## Fire Marshal Division

**RE: Mohler Homes Model  
46 Comm Park Lane  
Angier, NC 27501**

**Application Number: BCOM 1810-0001**

Drawing Name:
Life Safety Plan

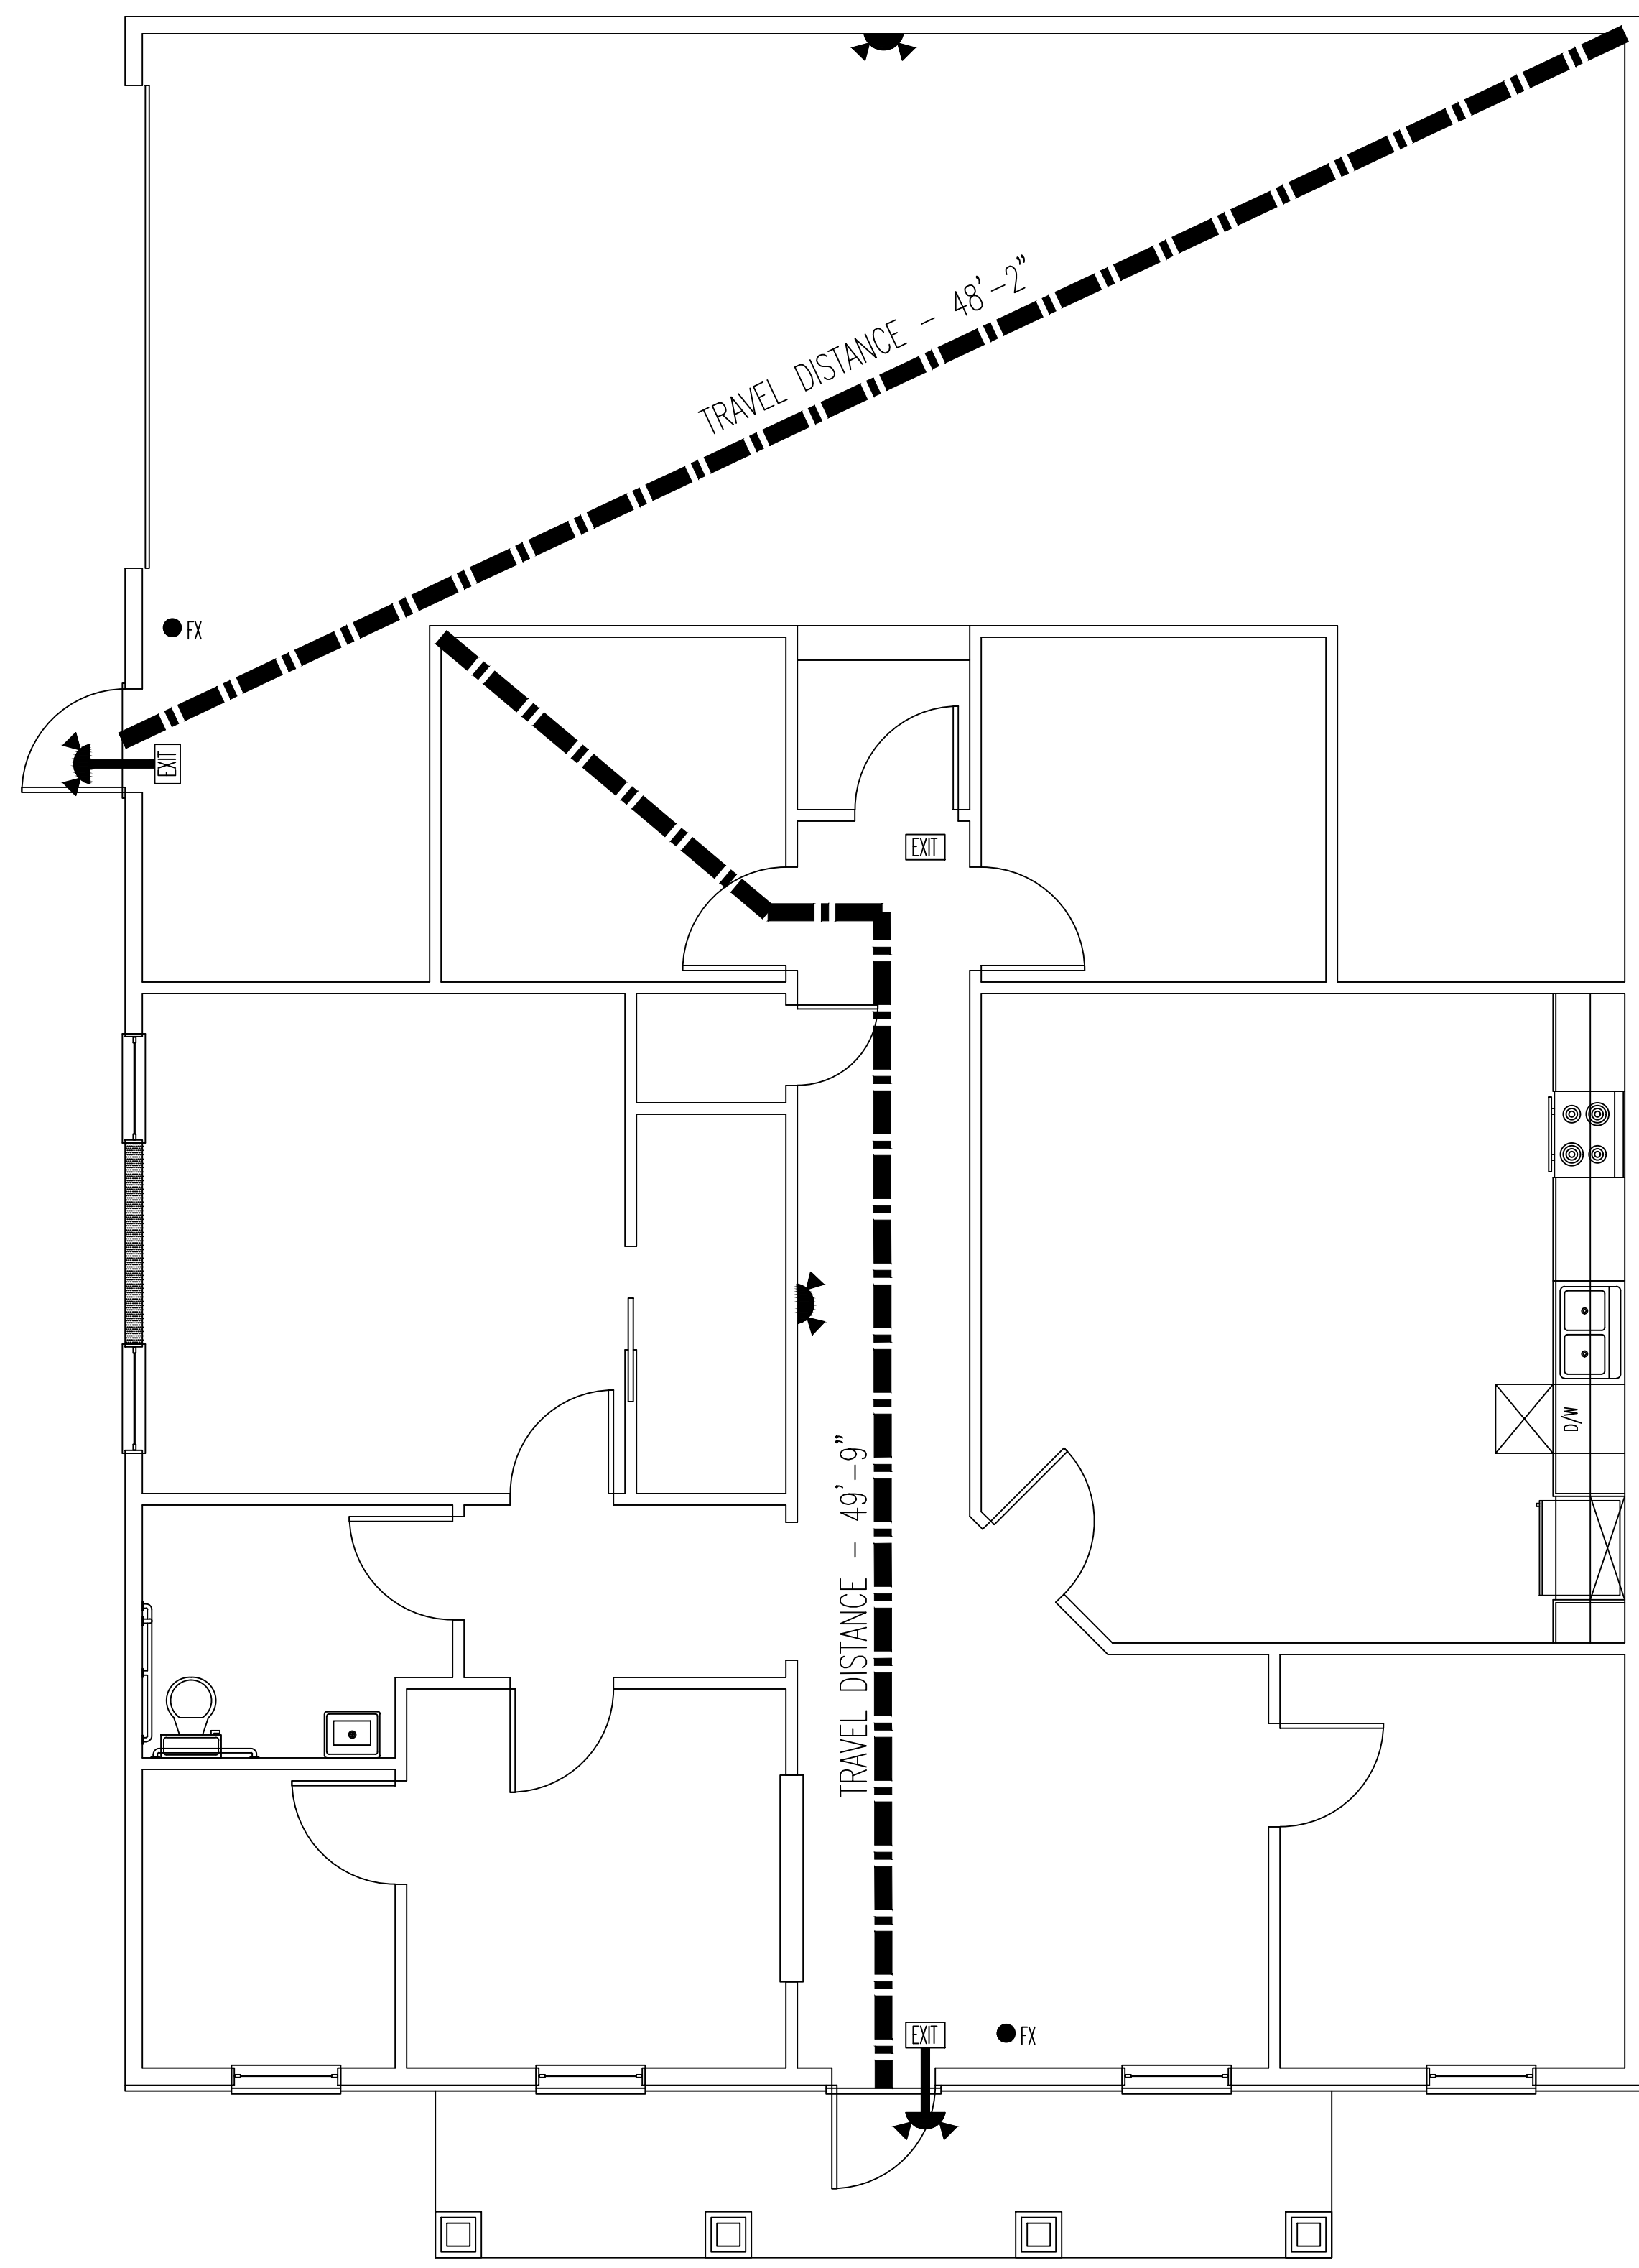
- **906.1 Fire Extinguishers**
  - Fire extinguishers shall be placed in approved locations, one in the area of the rear storage space and one in the front entrance area.
  - The fire extinguishers provided shall have a minimum rating of 2A 10B: C and shall not be installed higher than 5 feet above the finished floor.

- **1006.1 Emergency Lighting**
  - All emergency lighting, provided prior to upfit, shall be in proper operating condition at time of final inspection.
  - Any changes made in illumination requirements, due to equipment placement or storage arrangements shall be addressed before final inspection.
